**Consultation Response from KC,
Trees**

2025/91184 land off, Bretton Street, Savile Town, Dewsbury, WF12 9BZ

Erection of two storey industrial unit (Use Class E(g)(iii)), with associated car park, service area and other associated works

Date Responded: 26/08/2025

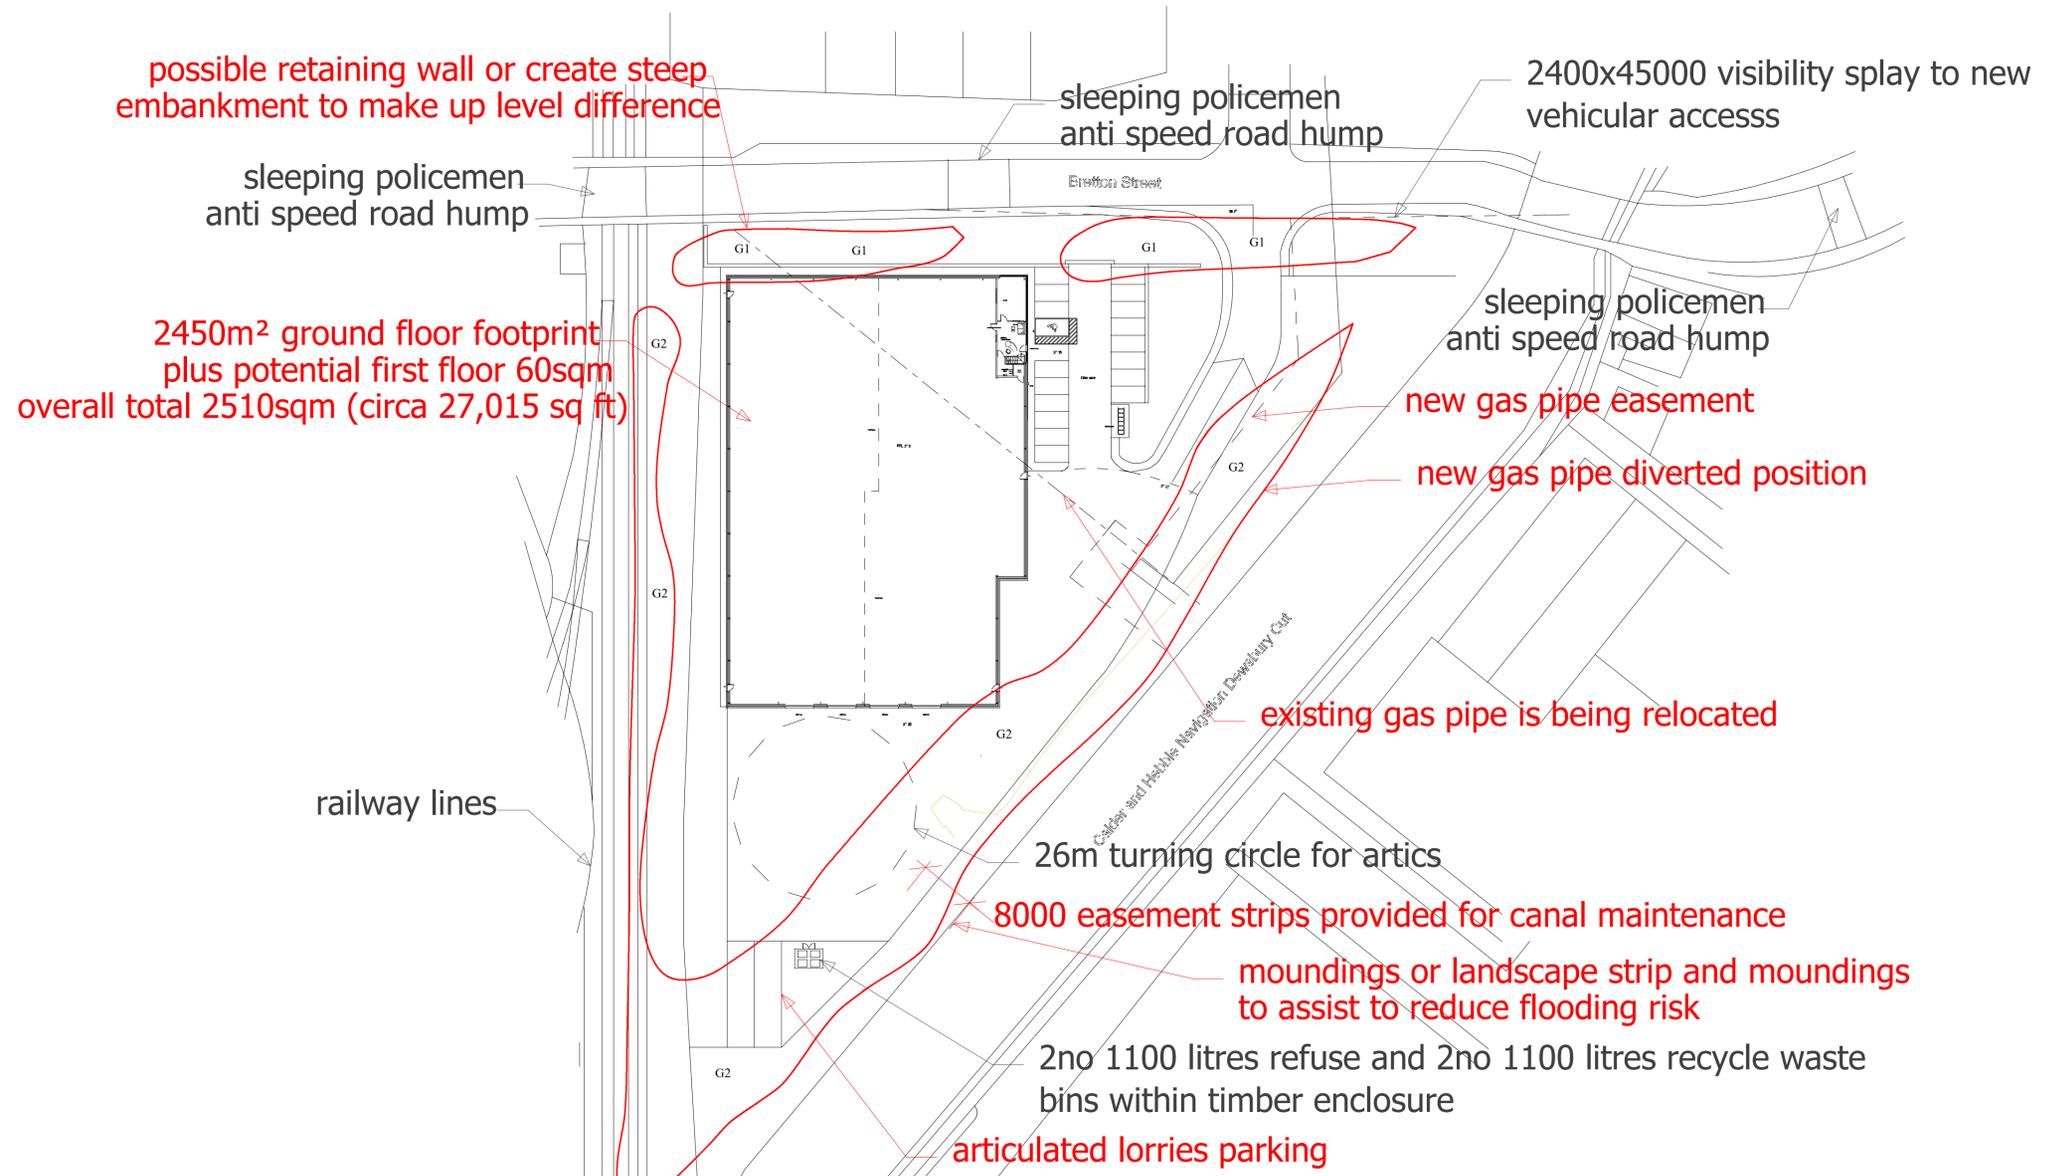
An AIA was also submitted in support of the planning application Ref: 22726-A/AJB, dated March 2025. The AIA shows all trees within the site for removal, including the trees along the frontage of Bretton Street and the entire Category B group which provides amenity value and screening into the site. Trees deemed fit for retention must be sustainably incorporated into new layouts wherever possible.

There is an objection from an arboricultural perspective. The proposal conflicts with adopted Kirklees local plan policy 33 and 24 (i).
